Please ask for: Ms Iqraa Malik
Email: iqraa.malik@terraquest.co.uk
Telephone: 0121 234 1390
Our Ref: FP/203/21/HH
Your Ref:
Date: 16th September 2021

Application for Planning Permission for Works or Extension to a Dwelling

Development: Erection of single storey side extension to create garage with balcony over following the demolition of existing carport
Location: 17 Blakes Road Felpham PO22 7EE

EXISTING GROUND FLOOR PLAN 1:200

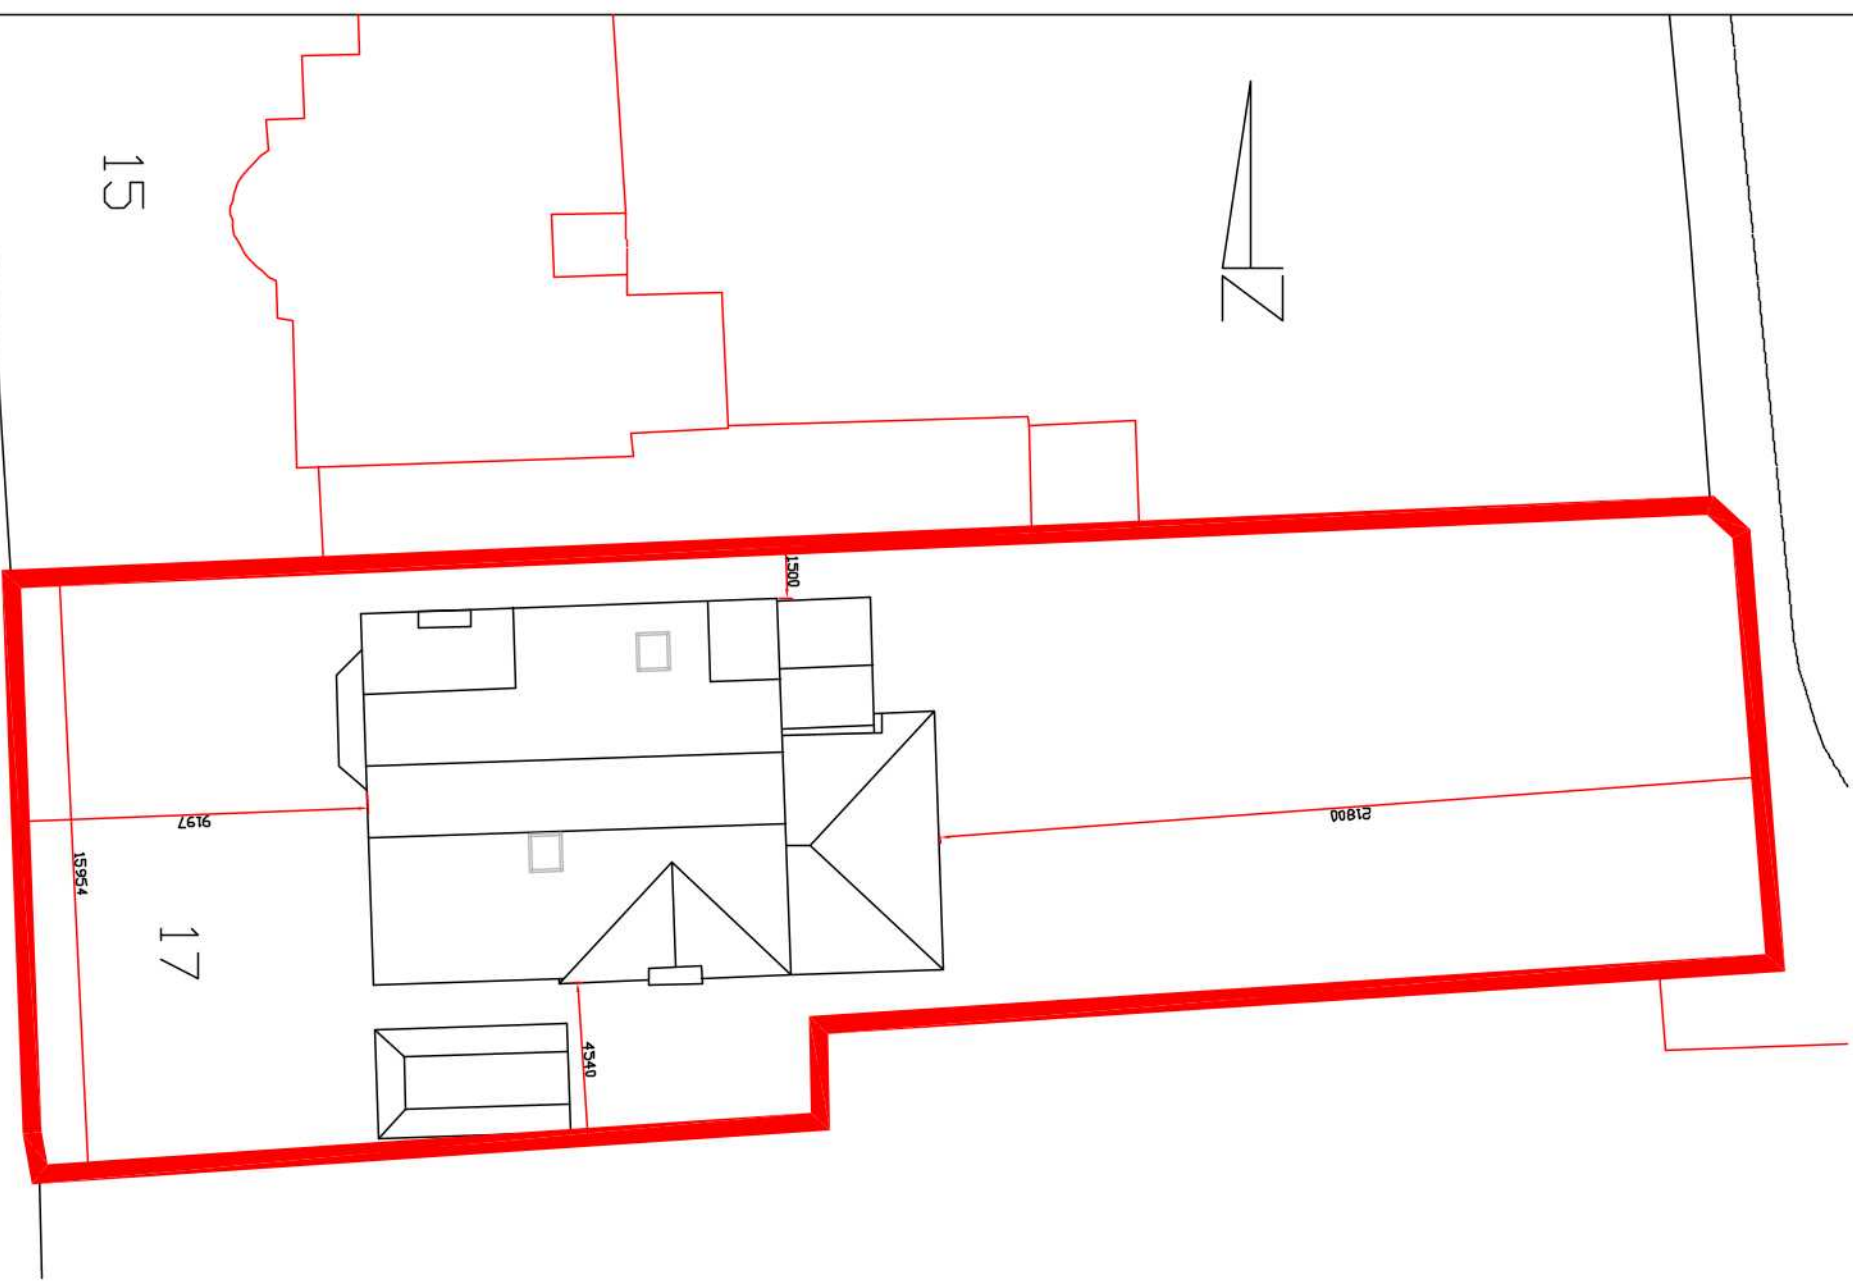
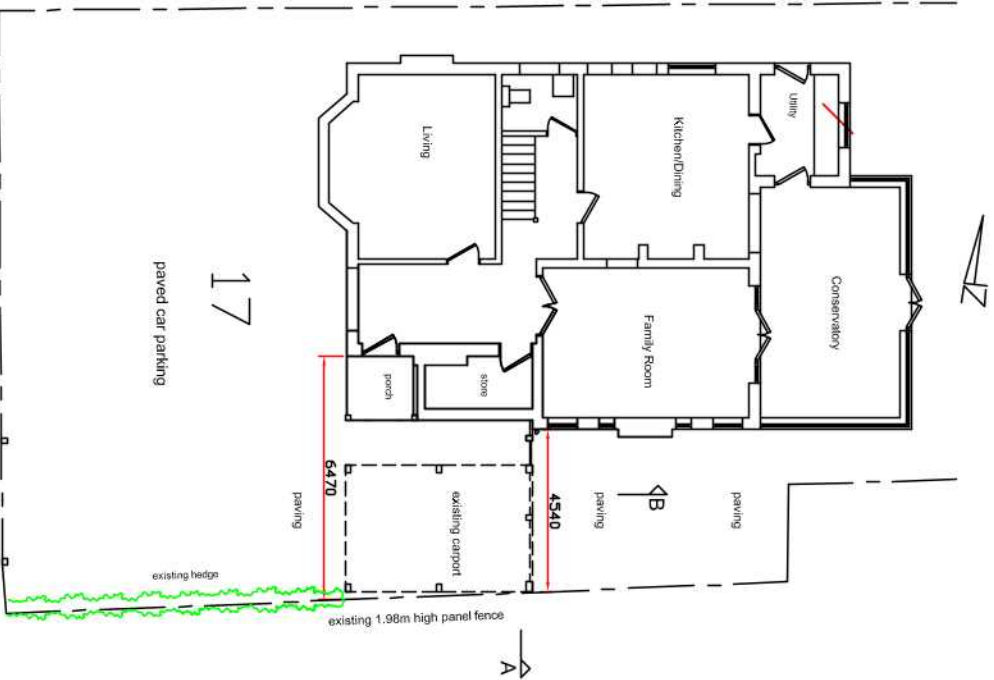
Please submit clearly labelled existing ground floor plan, existing roof plan and existing/proposed first floor plans at a scale of 1:50 or 1:100. Further details can be found in the Validation Requirements List.
